Application number: 2021/90800	
What is the application for?:	Redevelopment and change of use of former mill site to form 19 residential units
Address of the site or building:	Hinchliffe Mill, Water Street, Holmbridge, Holmfirth, HD9 2NX
Postcode:

User comments

HOUSE TYPE : UNIT 1

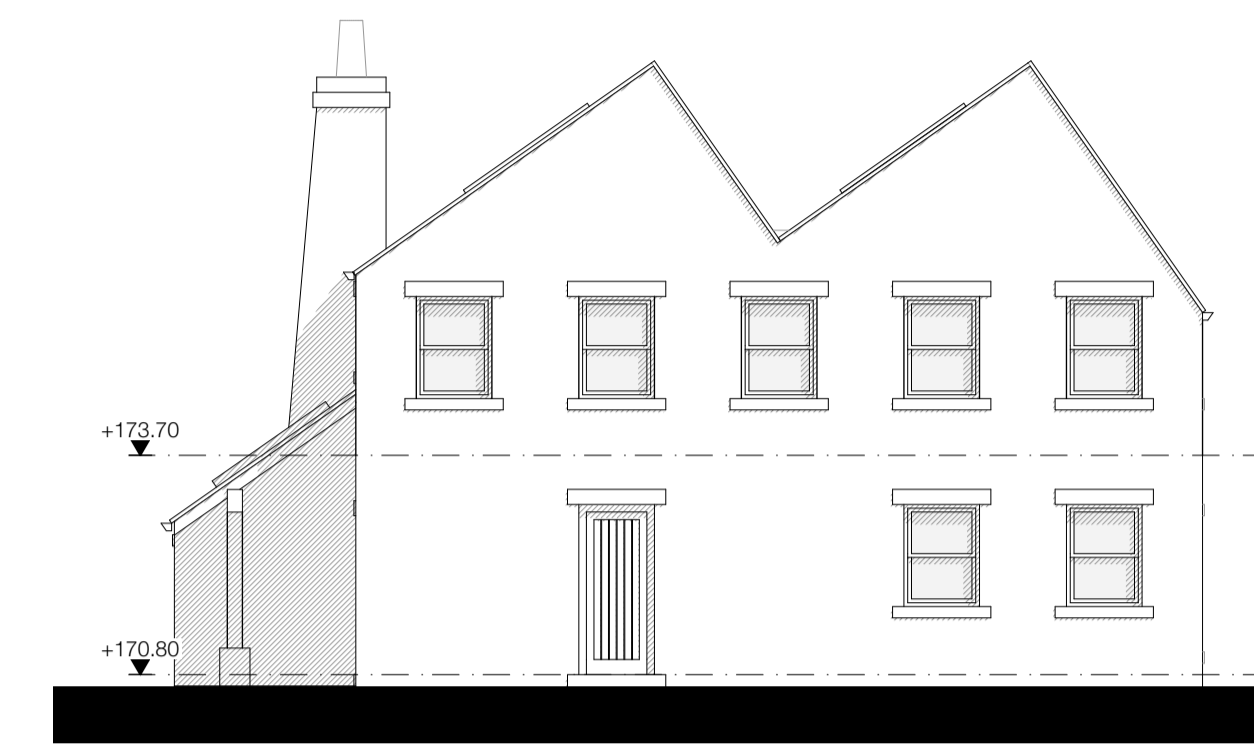
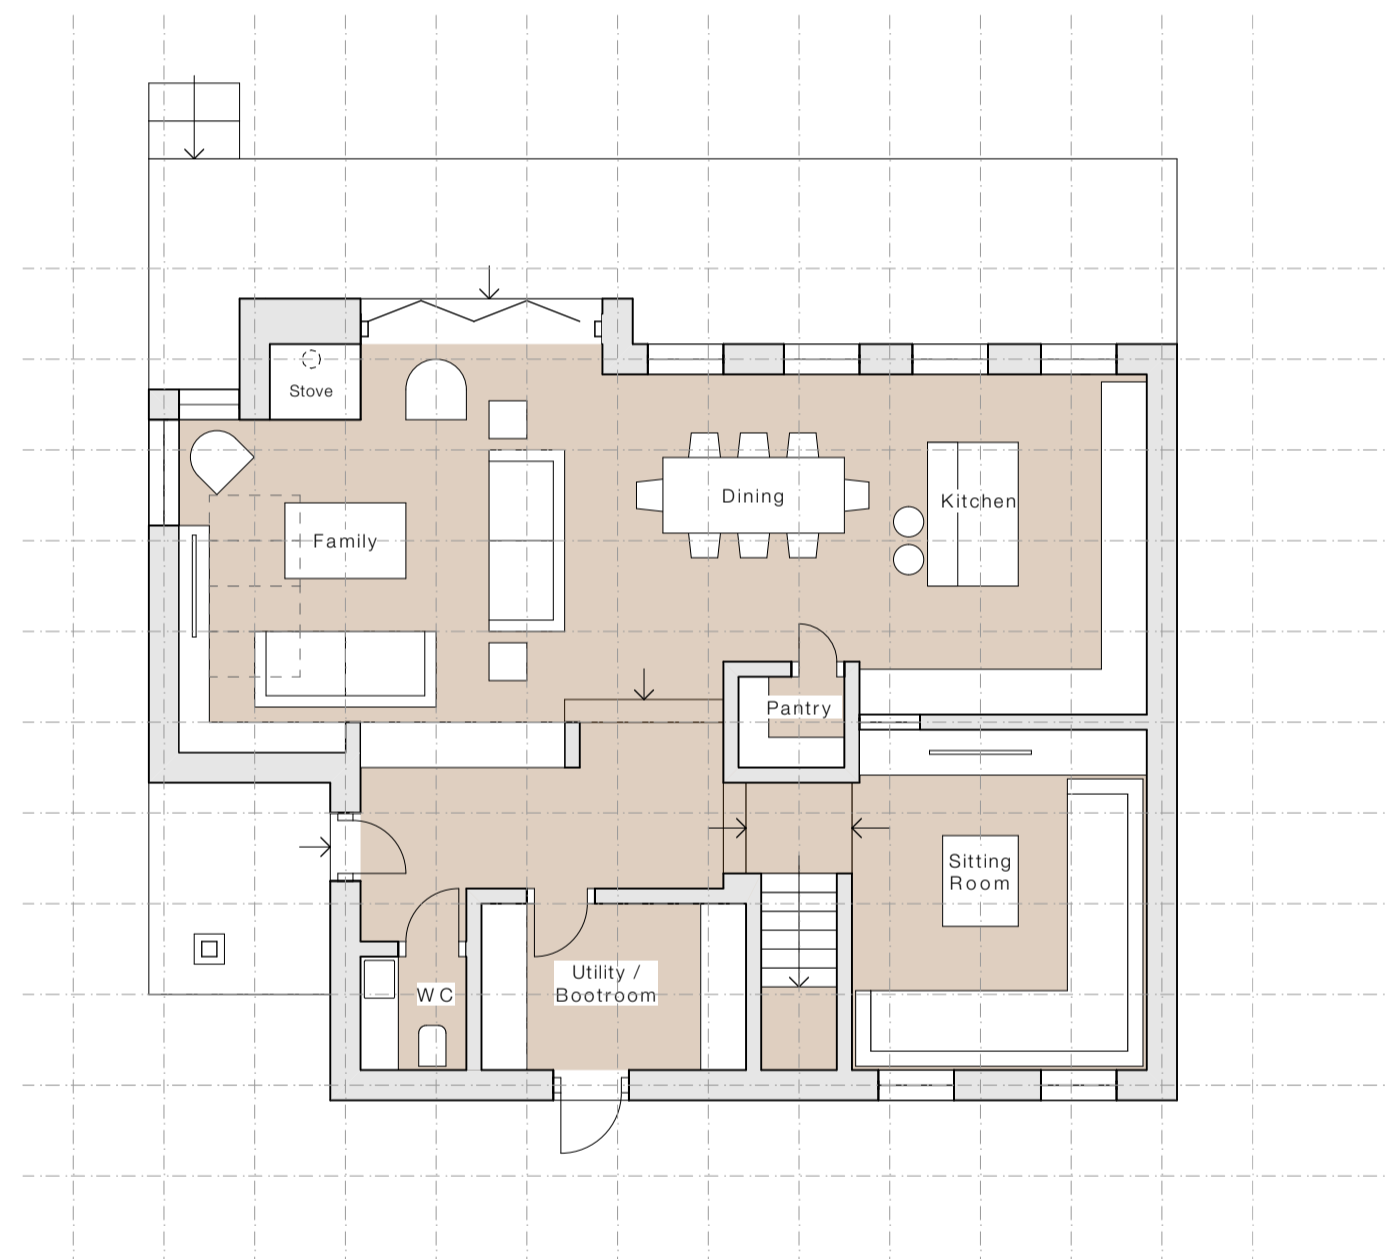
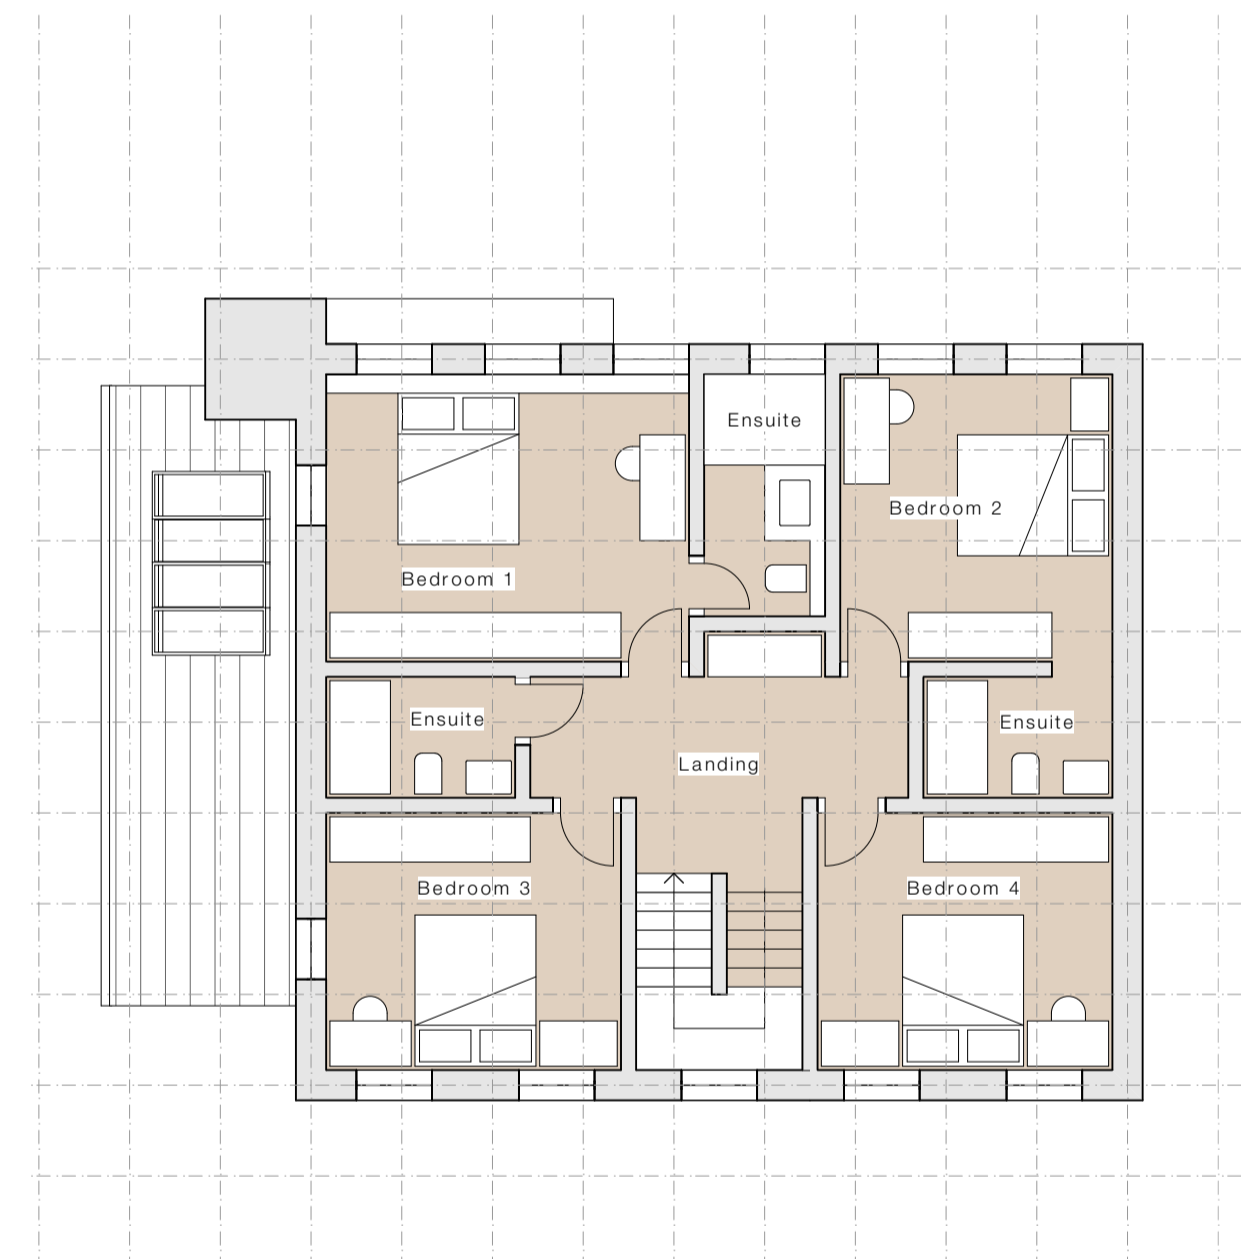
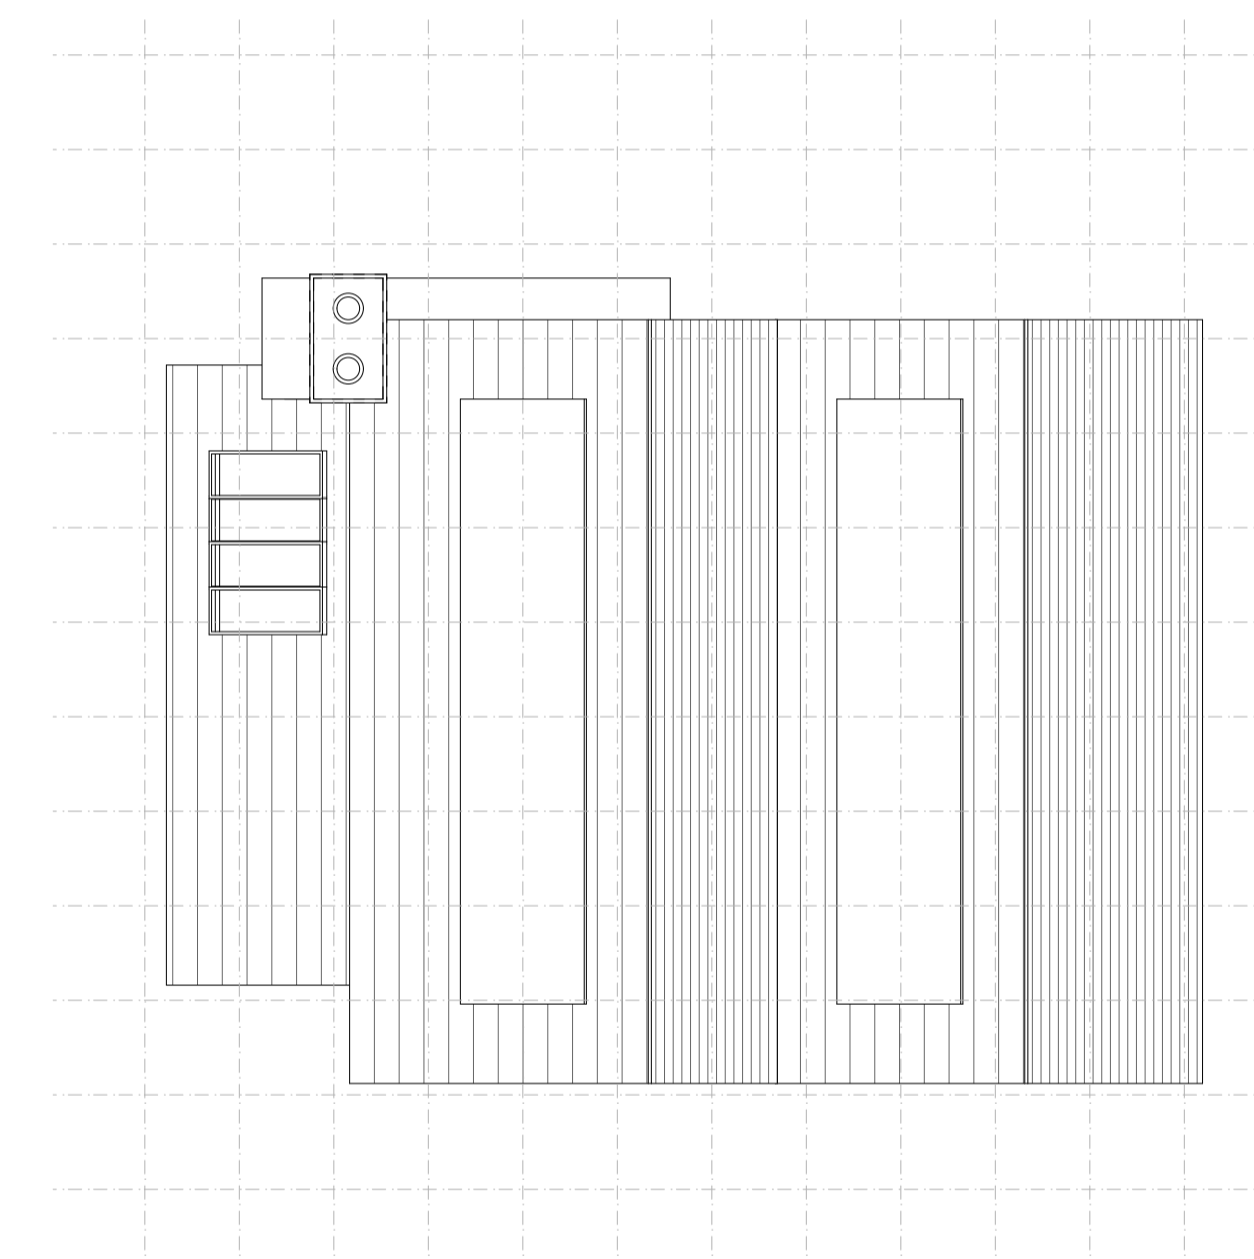
The scale and massing of plot 1 & 2 directly adjacent to the mill building, overlooking the dam are unduly dominant and out of scale with the heritage Class 3 asset mill building which would lose its local prominence, adversely affecting its village-scape merit and immediate setting. Historic England submitted concerns that previous plans presented a 'domestic' feel, at odds with the industrial character of the site which would not preserve or enhance the special interest of surrounding designated and non-designated assets and would be harmful to the character and appearance of the conservation area, and consequently cannot be supported. Complete removal of plot 1, or further reduction in scale and massing of plot 1 & 2 is required. Further design consideration is needed in keeping with the context of the industrial setting and surrounding properties in this conservation area.
